CITY OF ALBUQUERQUE

May 24, 2017

**RE: Oakland Ridge Subdivision
Grading Plan and Drainage Report
Stamp Date: 5/19/17
Hydrology File: C18D085**

Based upon the information provided in your submittal received 5/19/2017, the Grading Plan and Drainage Report is **not** approved for Preliminary Plat action by the DRB. The following comments need to be addressed for approval of the above referenced project:

FIGURE 4
OAKLAND RIDGE SUBDIVISION
SUB-BASIN BOUNDARY EXHIBIT

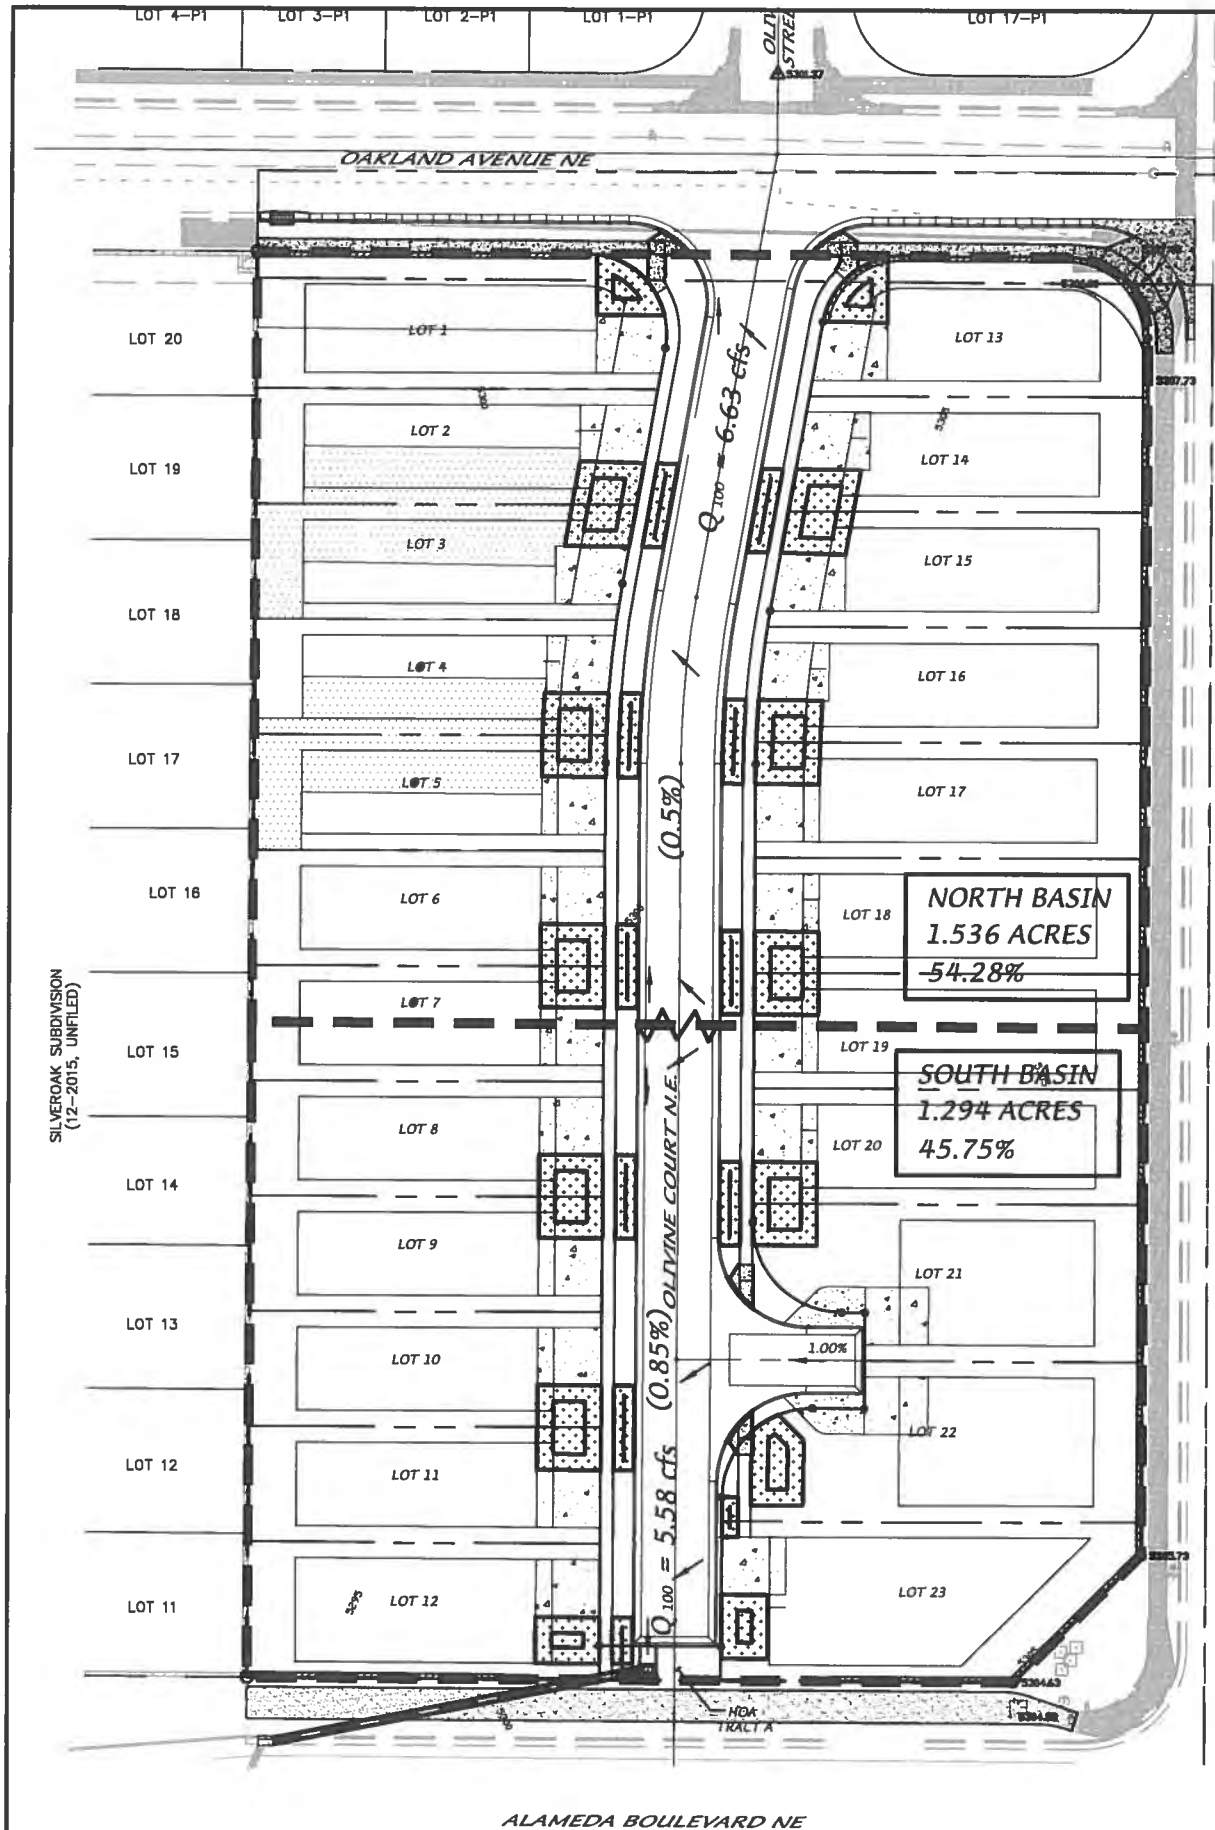
5. Please update Figure 4 as outlined above. Also please state the acreage of the North basin and the South basin.
6. Please update Figure 5. This should reflect the new basins, so Lot 6 & 7 information should be moved from the South basin to the North basin. Also Lot 18 & 19 information should be moved from the South basin to the North basin.
